Sent: 05 January 2026 13:39
To: DC Admin
Subject: Planning Application 2025/93313 - 68 Oxford Road, Dewsbury, WF13 4EH

Further to my formal objection to the above Planning Application, I wish to make the following comments:-

Proposed Second Floor Plan - 1:100

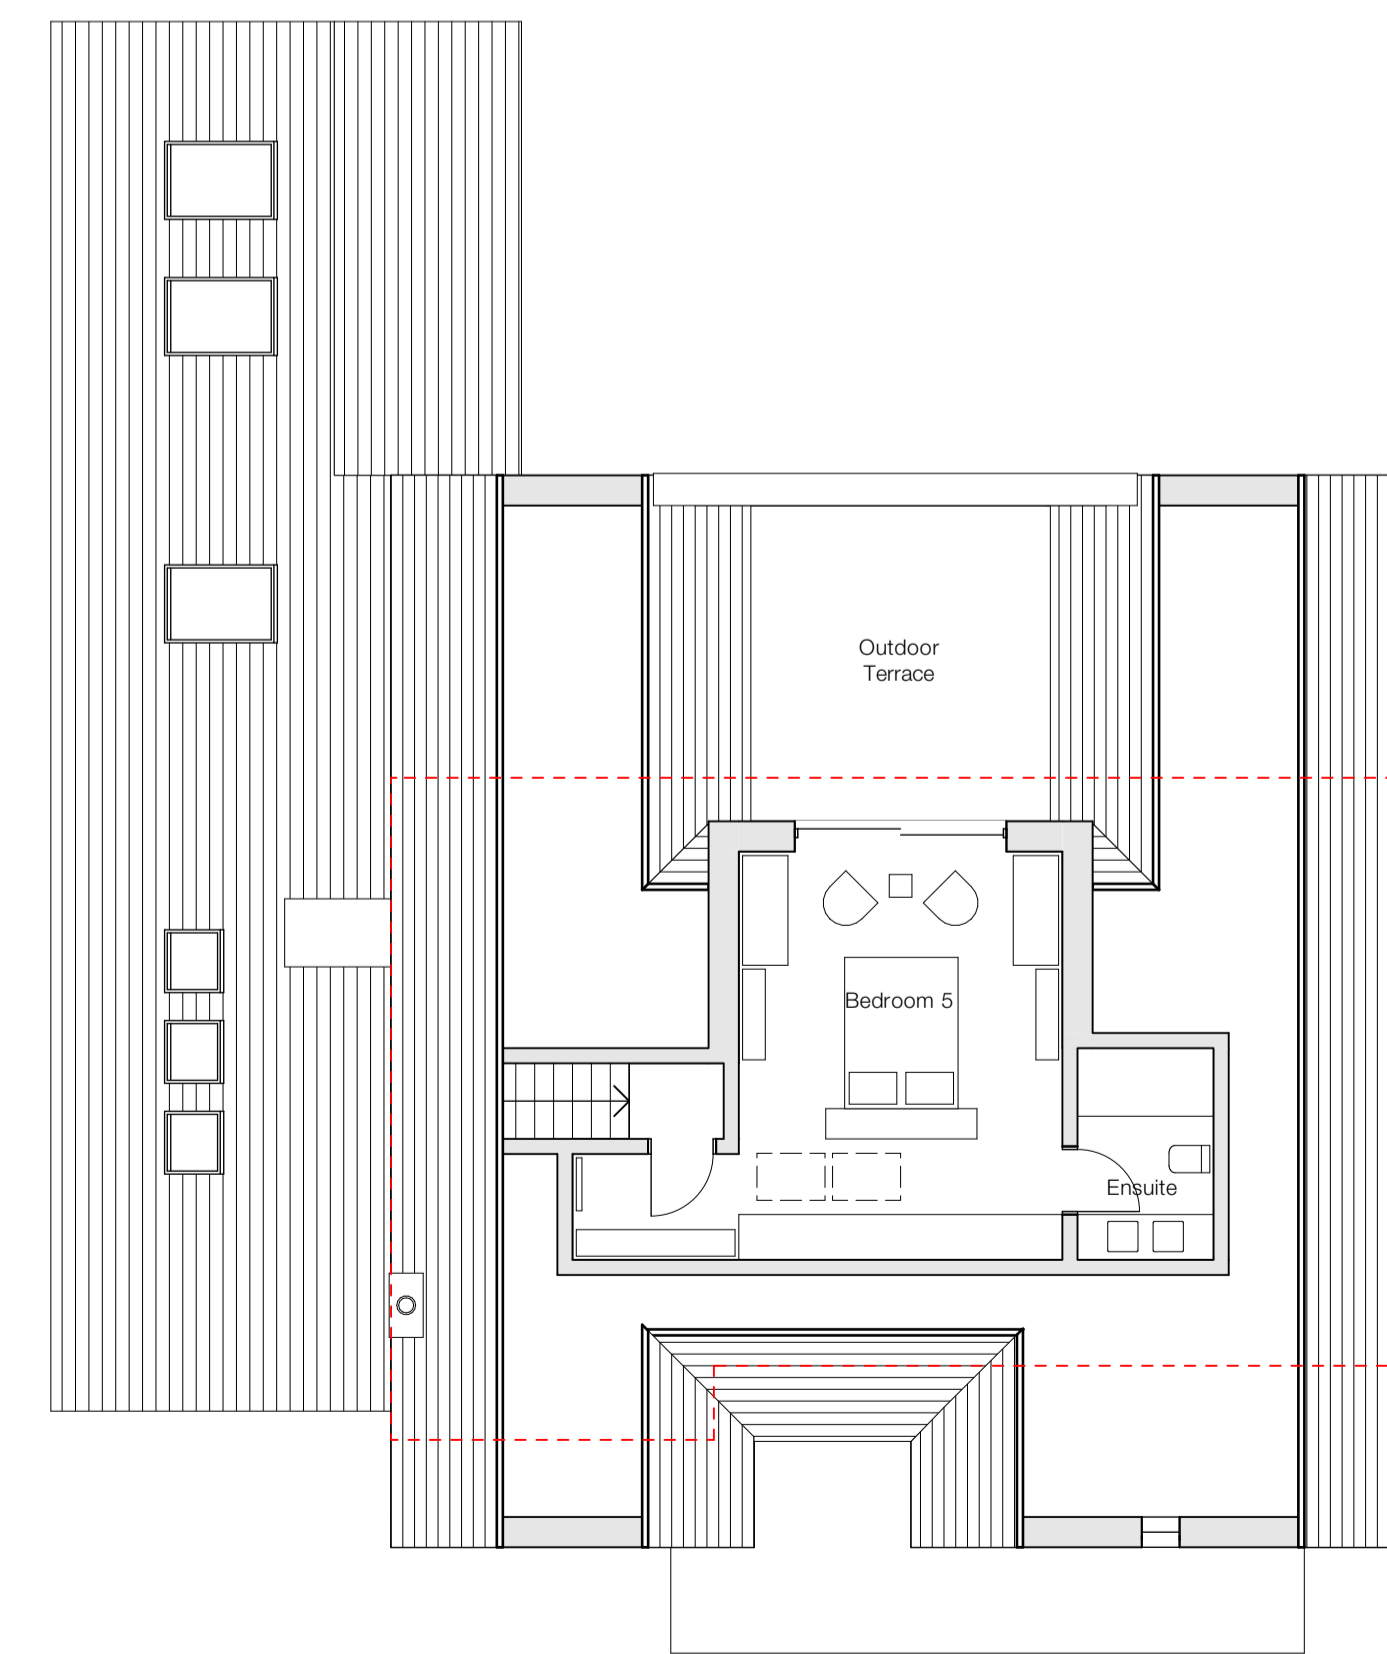
THE PLANS - There is an additional window shown on the proposed, east aspect, second floor plan, which will overlook my neighbour at No. 66 Oxford Road, in particular into his lounge side window, which the applicant failed to acknowledge, or show within their Planning Statement (the photograph showing the side of his garage, not his single storey bungalow).
